WEST SUSSEX COUNTY COUNCIL CONSULTATION

TO:	Arun District Council - FAO: Simon Davis
FROM:	WSCC - Highways Authority
DATE:	21 October 2020
LOCATION:	Bonhams Field, Main Road, Yapton, BN18 0DX
SUBJECT:	Y/98/20 Erection of 75 No. dwellings with associated parking, public open space & the creation of a new vehicular access. This application affects the character & appearance of the Main Road/Church Road Conservation Area & affects the setting of listed buildings.
RECOMMENDATION:	More Information

Image showing proposed revised layout plan

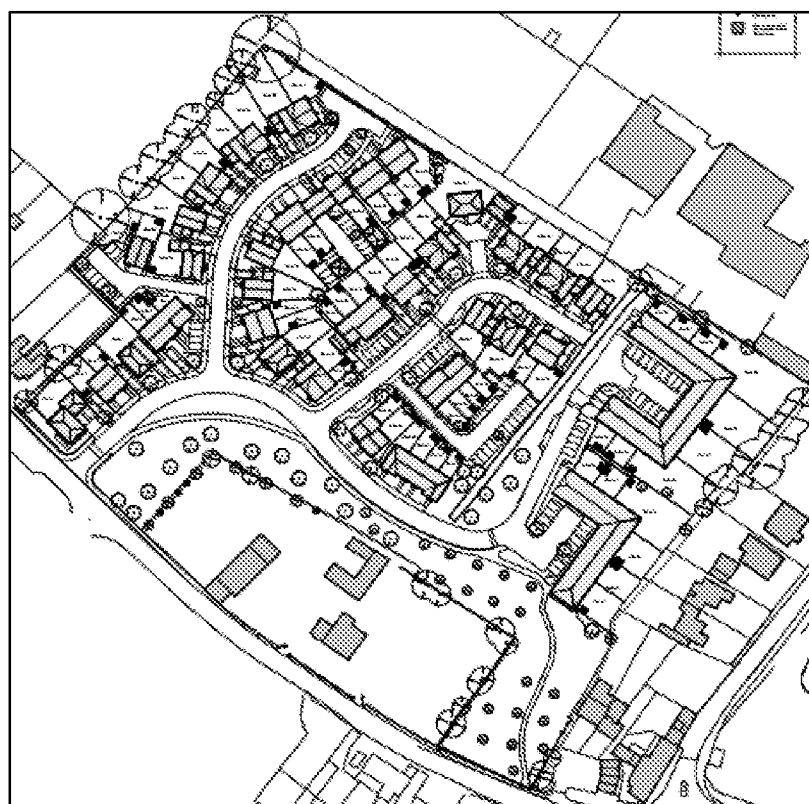
Within the site there is a combination of shared surface and segregated footway. Where the access joins with Main Road, separate footway has been included to separate pedestrians from vehicle traffic. It is unclear where pedestrian crossing points/dropped kerb within the site to facilitate

movement for all users will be positioned. Whilst this can be finalised at detailed design it would be useful for the plans to indicate these points at key junction/areas along the pedestrian desire lines.

A link from the east of the site, through open space and to the south east corner will provide a shorter route for pedestrians from this area to link with footway along Main Road. As commented on under Y/1/17, this path is shown as loose gravel and would not be practical for all users. A bound material should be used and ideally the area should be lit. These details can be confirmed at detailed design stage.

It is also noted that access to car parking spaces within the site appear to show kerbed radii, although it is acknowledged that the landscape plan refers to these as crossovers. All access to parking spaces should be designed as crossovers with the footway shown as continuous across site frontages (not kerbed radii). The applicant may also wish to consider length of extended crossover for plots 33-37 and whether landscaping can be utilised to provide respite for vulnerable users/pedestrians crossing this area.

As part of reserved matters application Y/72/20 (land north of site for 70 x dwellings), further information was sought on the proposed pedestrian/cycle link joining the two land parcels. No reference to this is made with the current application. Further clarification is sought on the proposed link from the northern hammerhead area to the adjacent site. Connectivity within the site could also be improved by providing a pedestrian/cycle link between plot 19-22 and plots 39-41.

The LHA have made a full assessment of the car parking proposed. Counting garages as 0.5 space the development provides a total of 135 x allocated spaces. Some of the plots do not meet required 2 or 3 spaces per dwelling because of the garage element (plots 4, 11-13, 15, 17, 24, 27-28, 31-33, 40-41, 43, 45-46, 49-50). Furthermore, the garages to plots 4, 31 and 49 would benefit from slight widening as they are currently just less than 3m width. It is also advised that internal garage doors open outward as some of these open inward which further restricts available space. The LPA may wish to seek additional parking where garages are provided in order to meet the anticipated demand.
